TO: Dan Valoff, CDS
FROM: Christina Wollman, Planner II *CW*
DATE: February 16, 2010
SUBJECT: Forest Ridge Plat LP-08-00014

TO: File
FROM: Douglas D'Hondt
DATE: February 16, 2010
SUBJECT: Surface Water Issues for Forest Ridge Development

DRAWN BY	DATE	JOB NO.
MFRN/GW	12/09	08008
CHKD BY	SCALE	SHEET
D. NELSON	1"=200'	2 OF 6

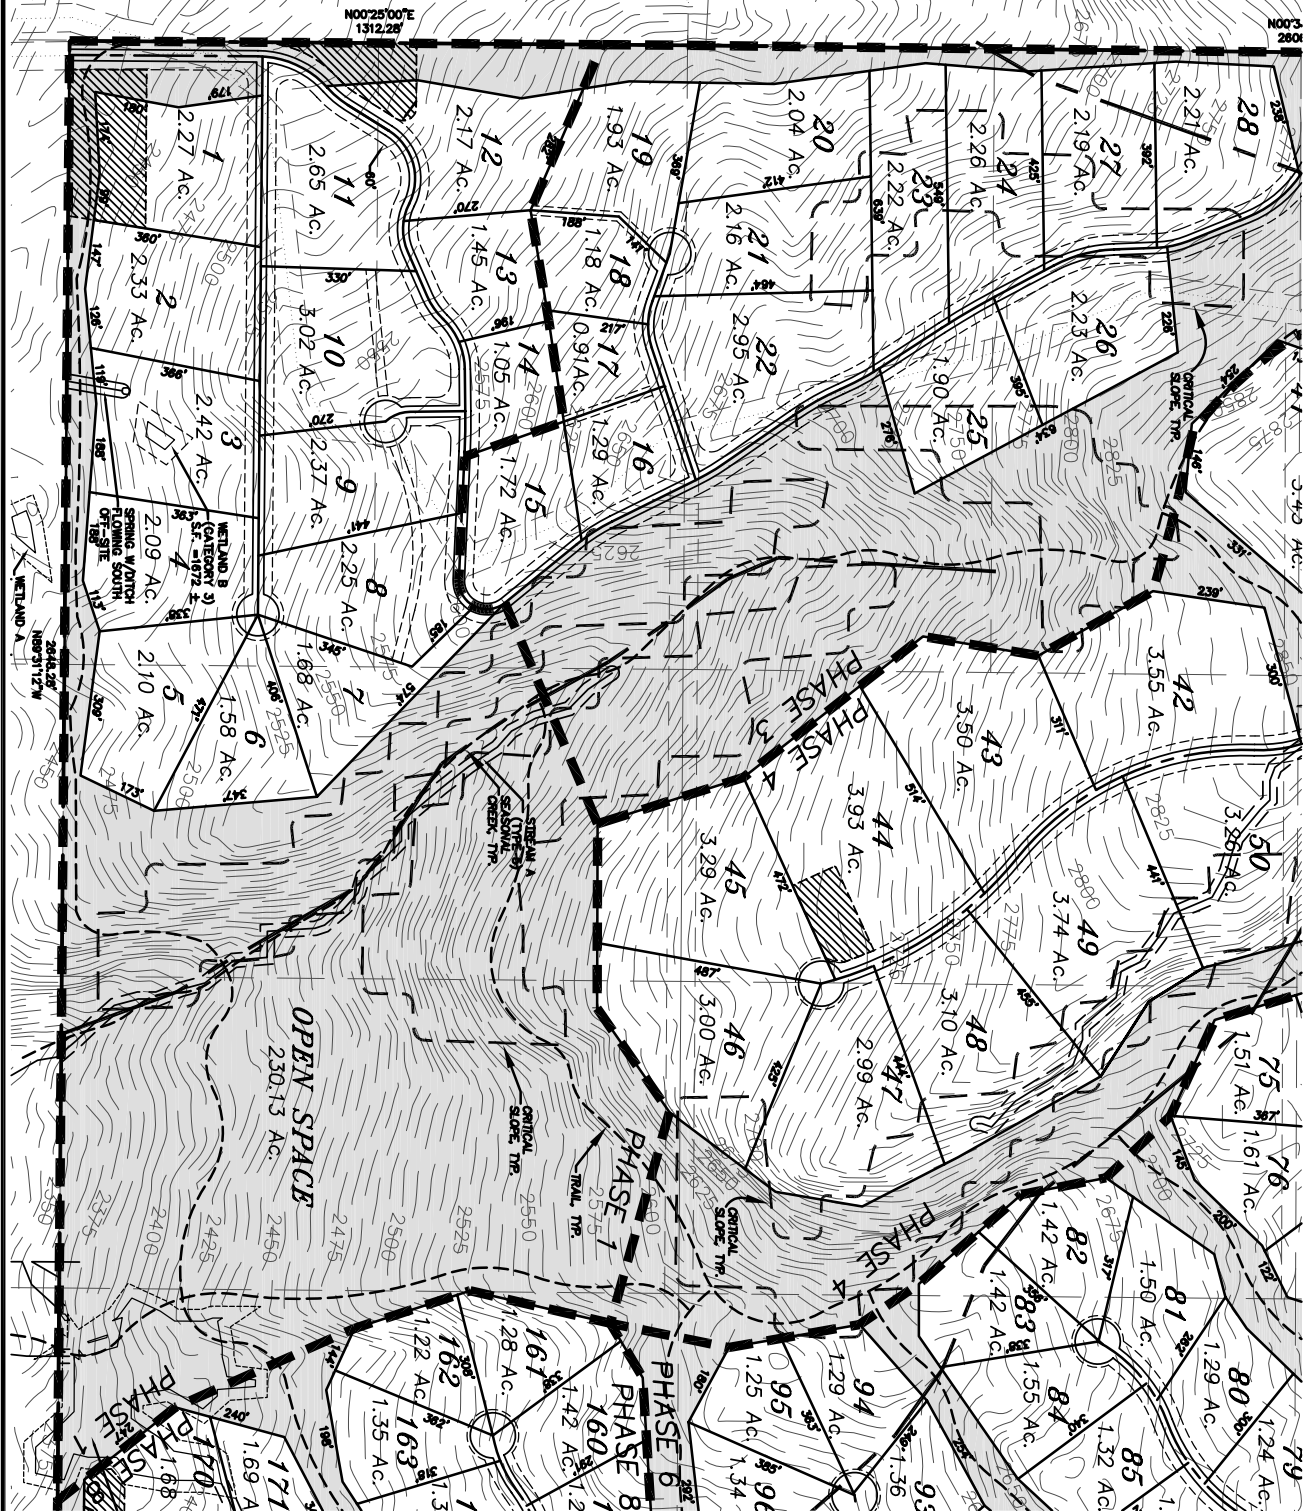
7. The scale depicted on the maps appears to be inaccurate and should be verified.
